V1_Final Drainage Report_COMMENTS.pdf Markup Summary

WILLOW SPRINGS ESTATES SUBDIVISION FIL 2

DRAINAGE LETTER

PCD File VR264

EXISTING & PROPOSED DRAINAGE CONDITIONS

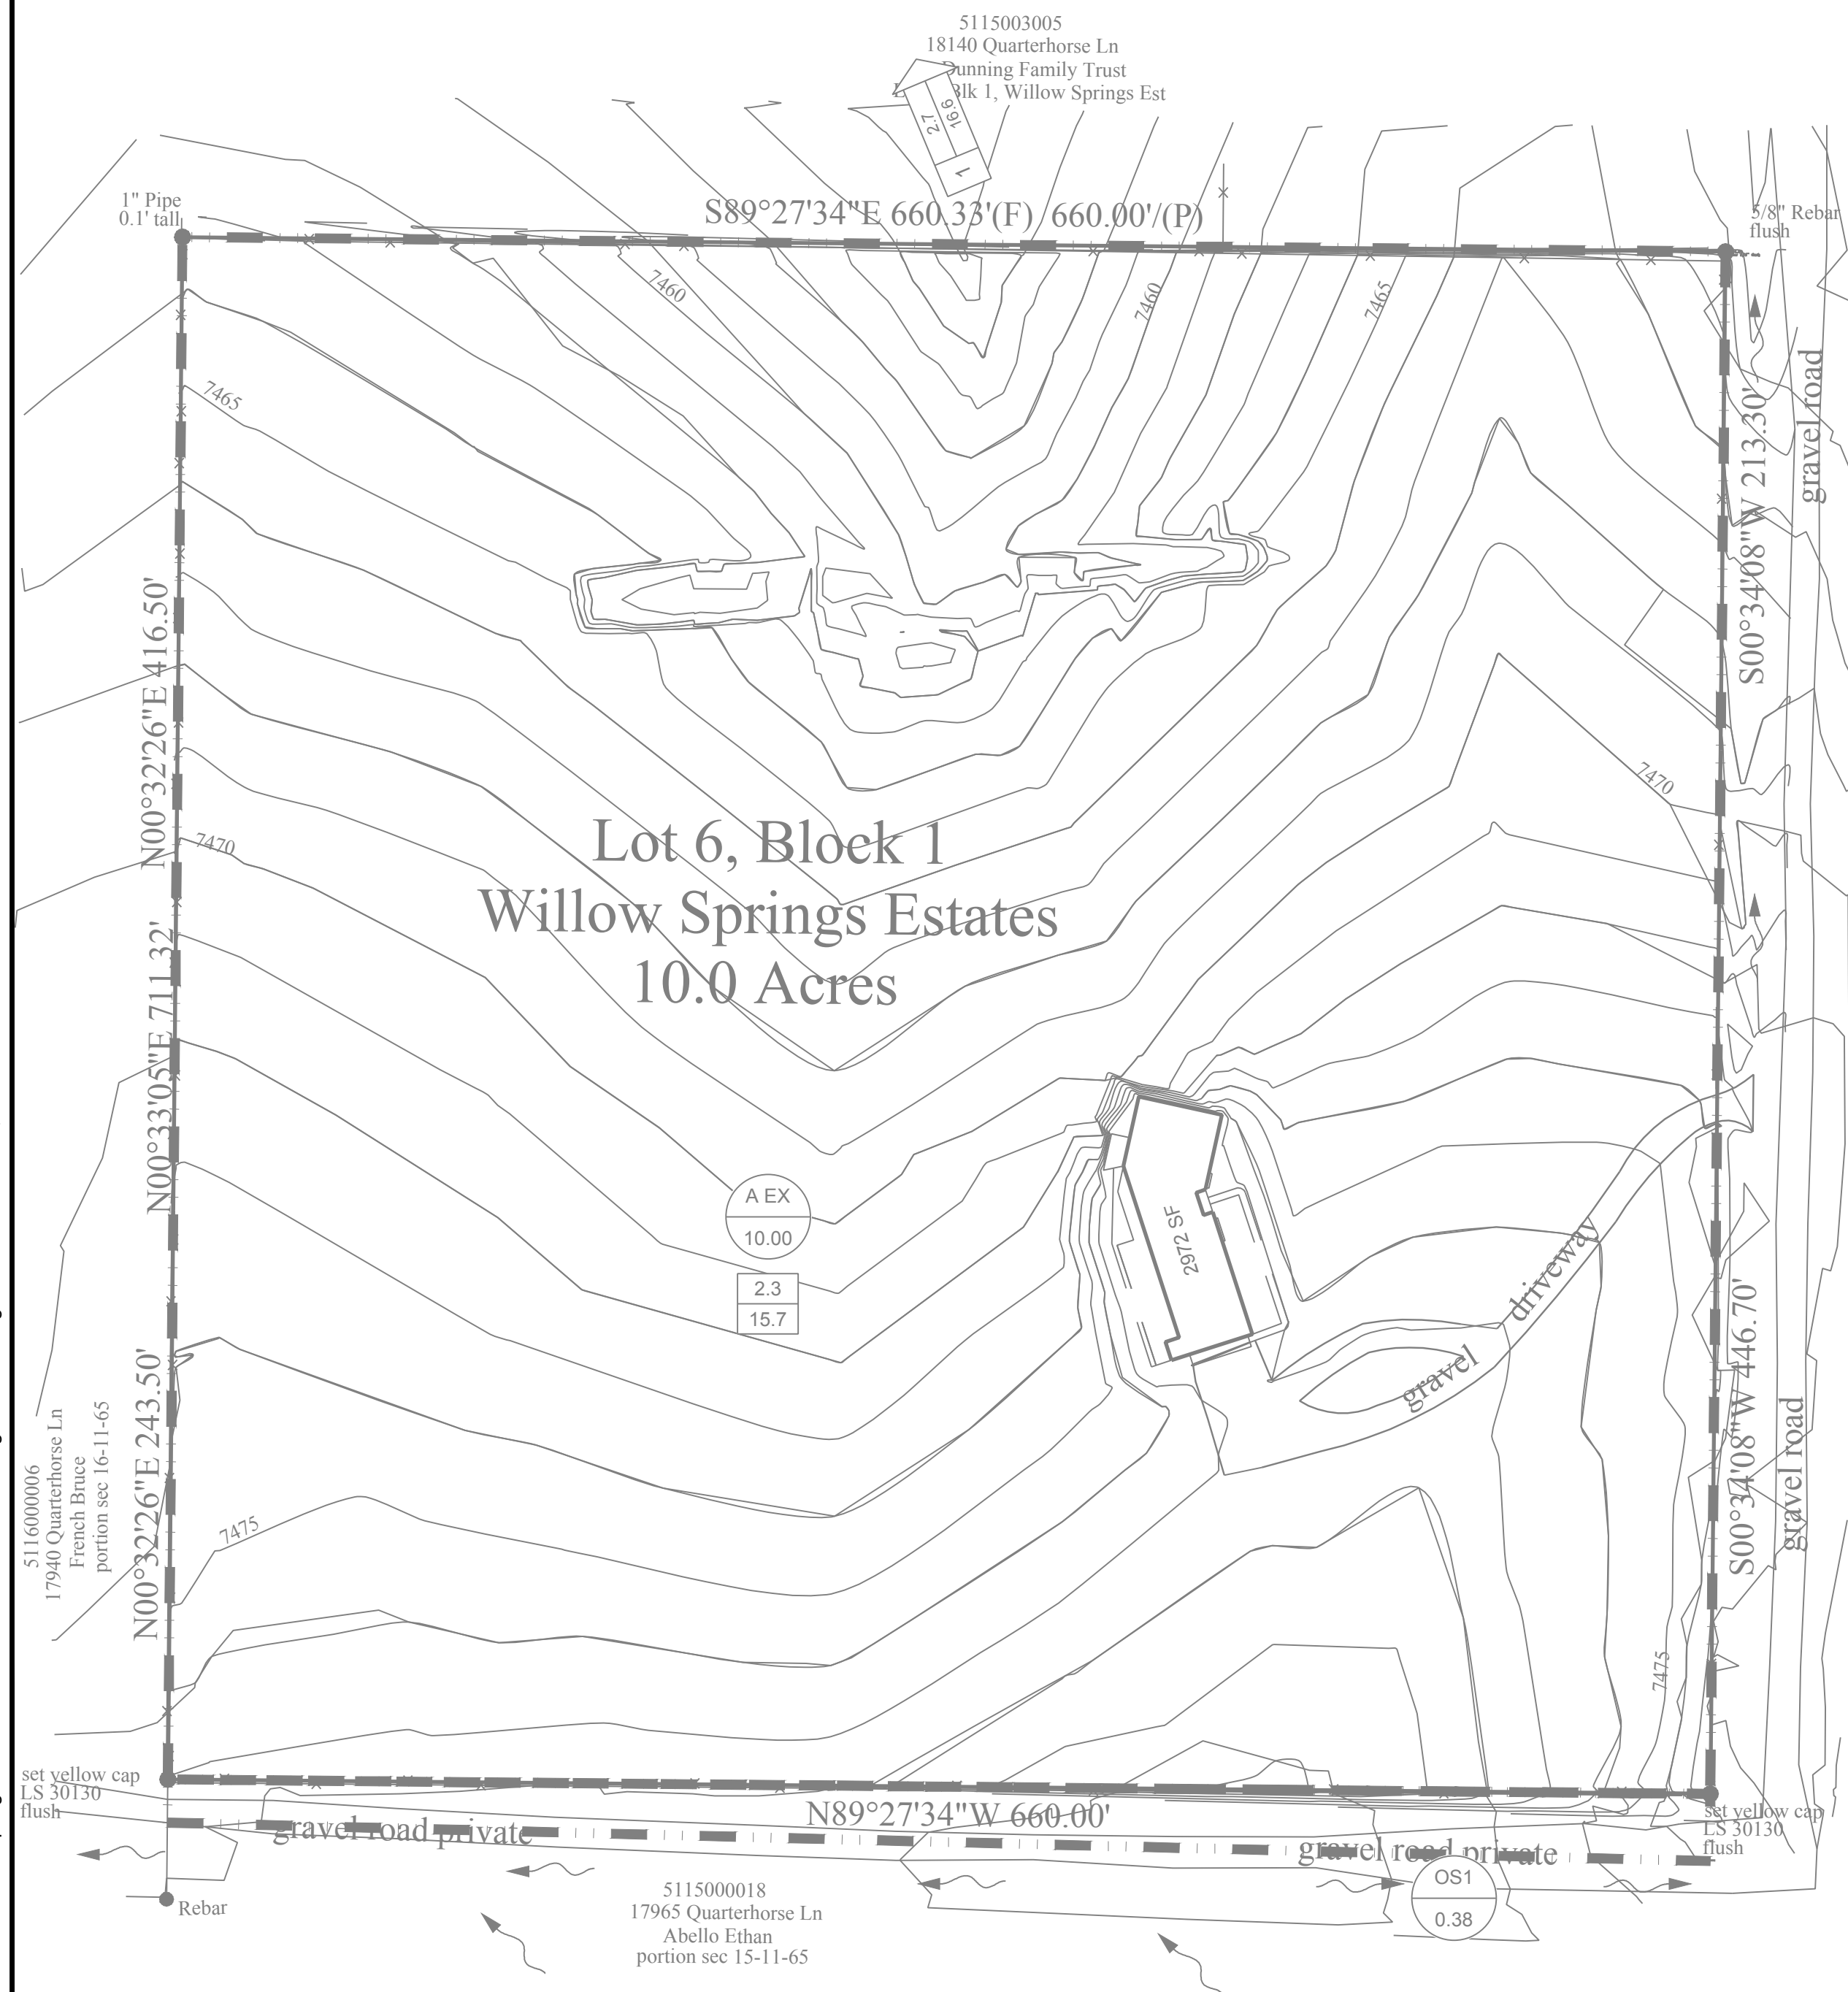
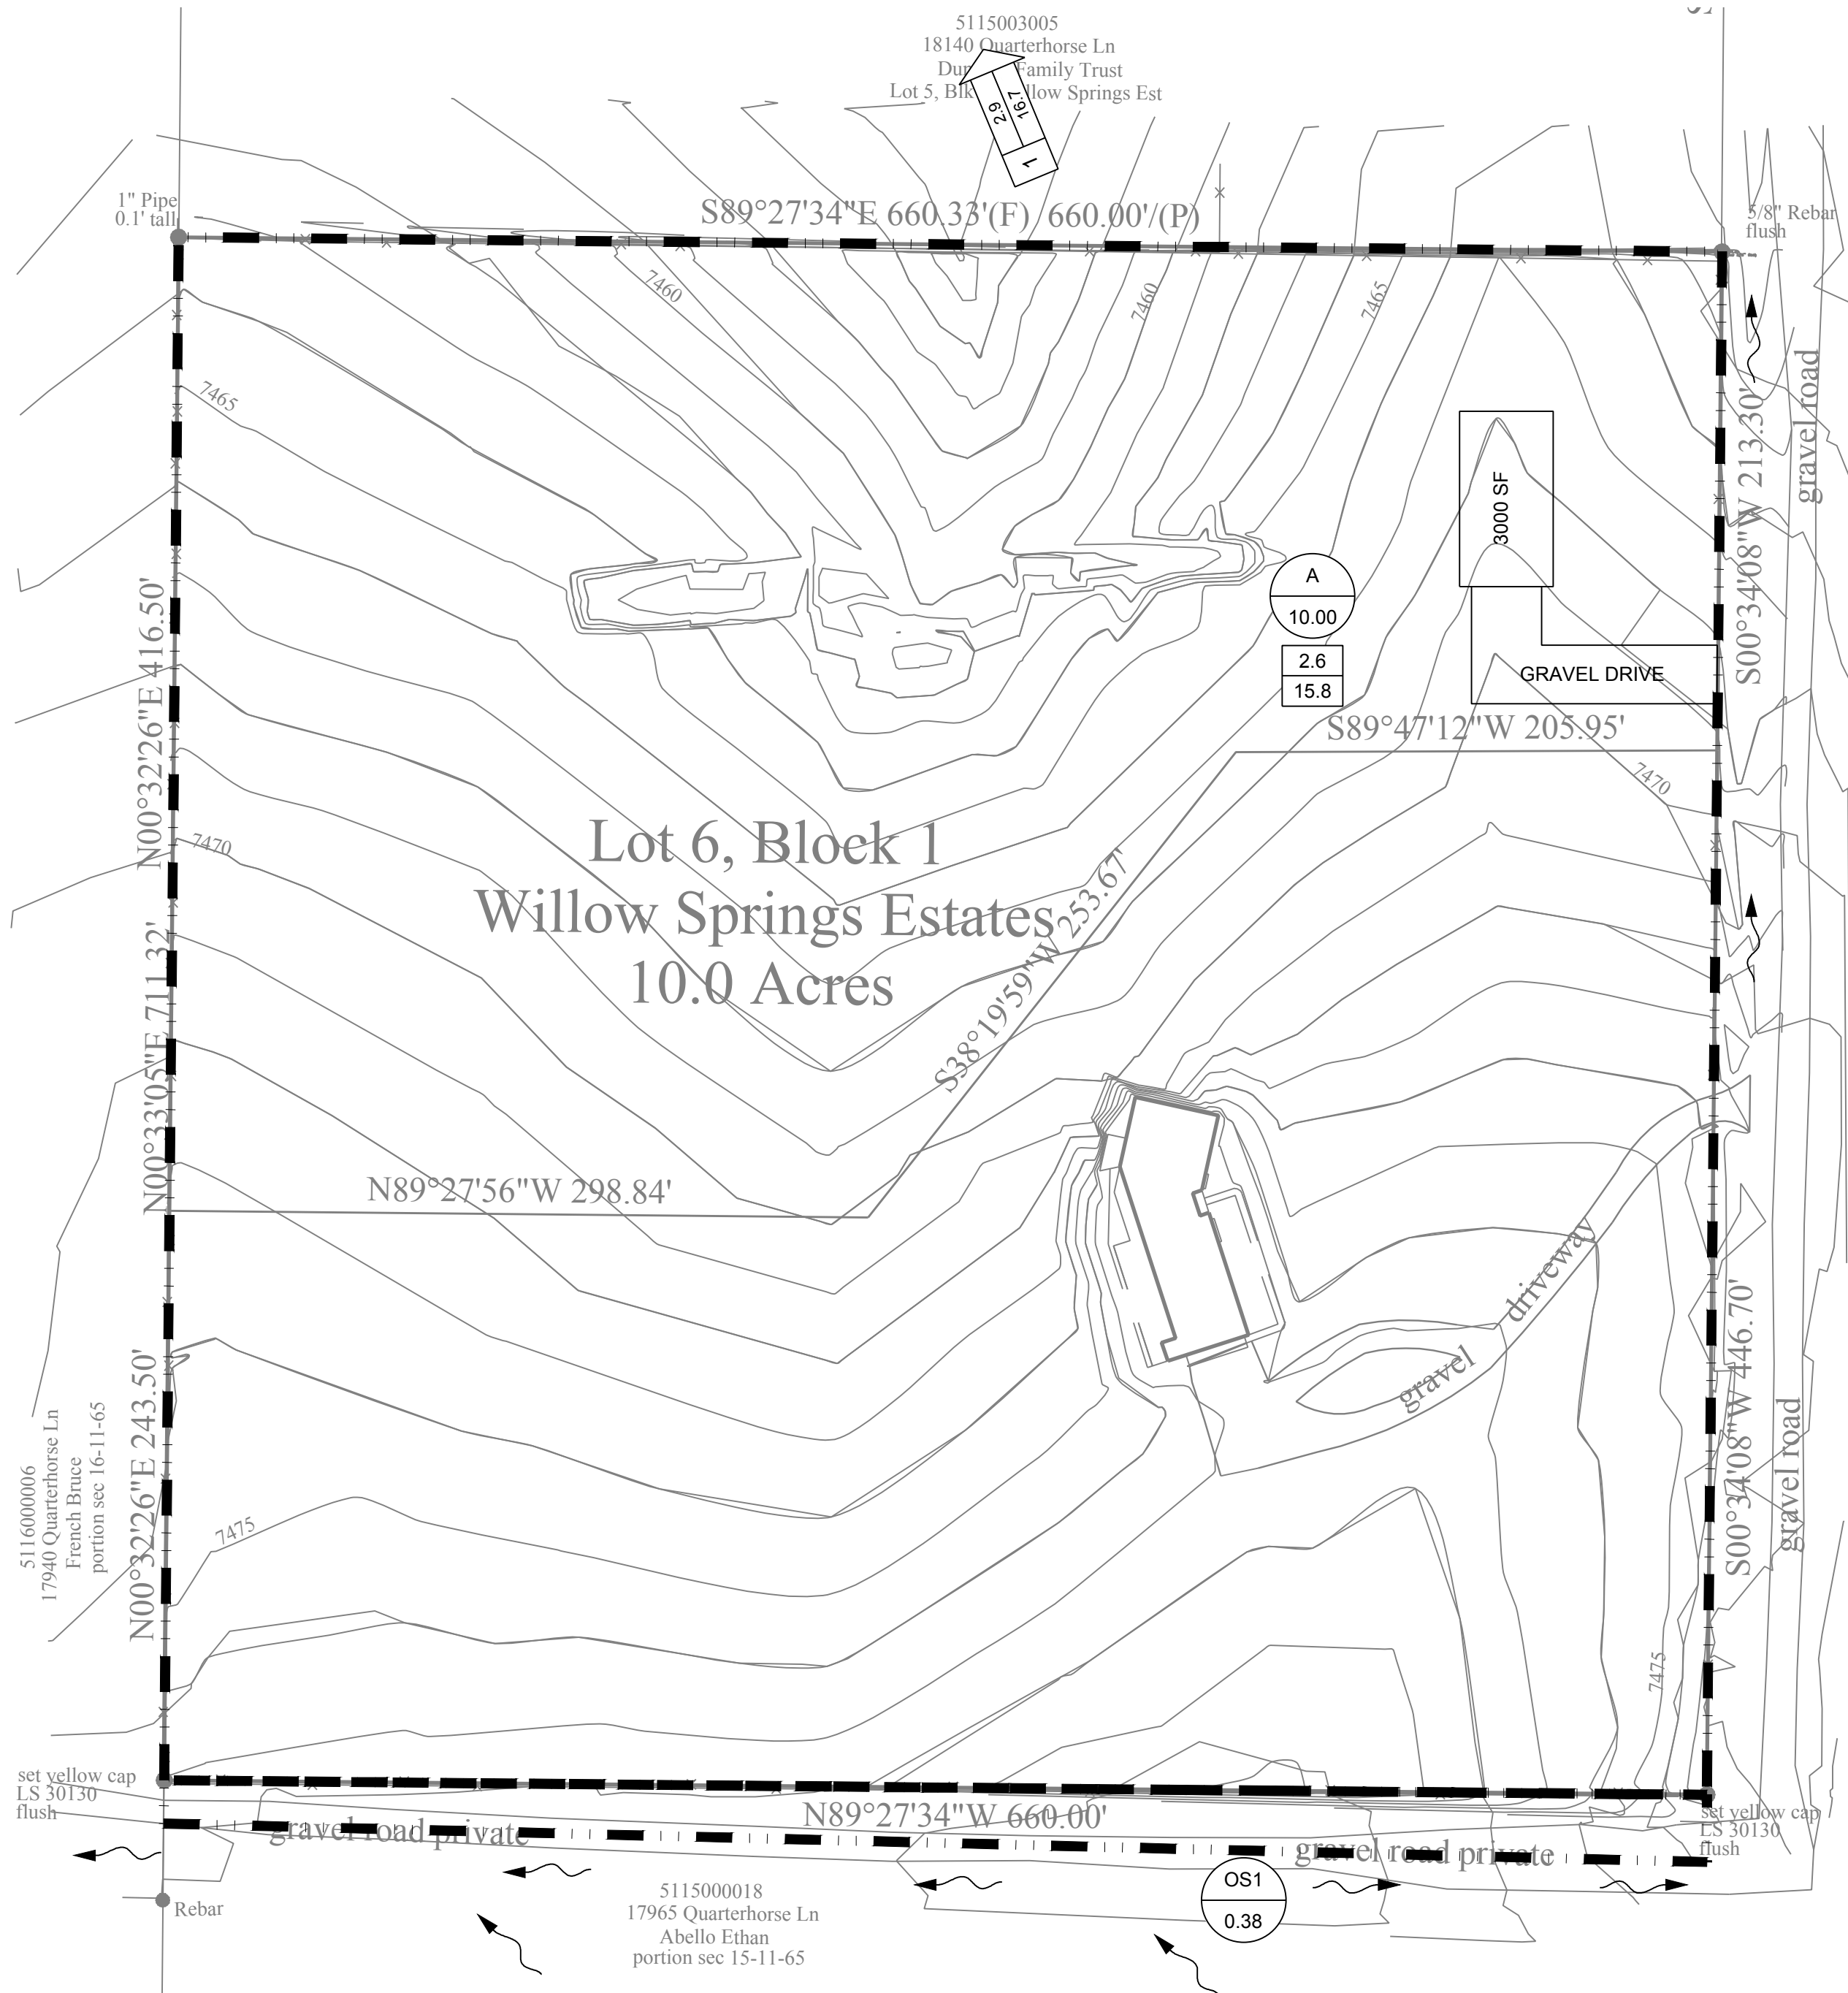
provide proposed grading around new home site.

Please include flow arrows and/or flow path on both site maps

Please include flow arrows and/or flow path on both site maps

please show culvert for new driveway.

please indicate if there is a flow path here. a drainage easement or no build area may be required

please indicate if there is a flow path here. a drainage easement or no build area may be required
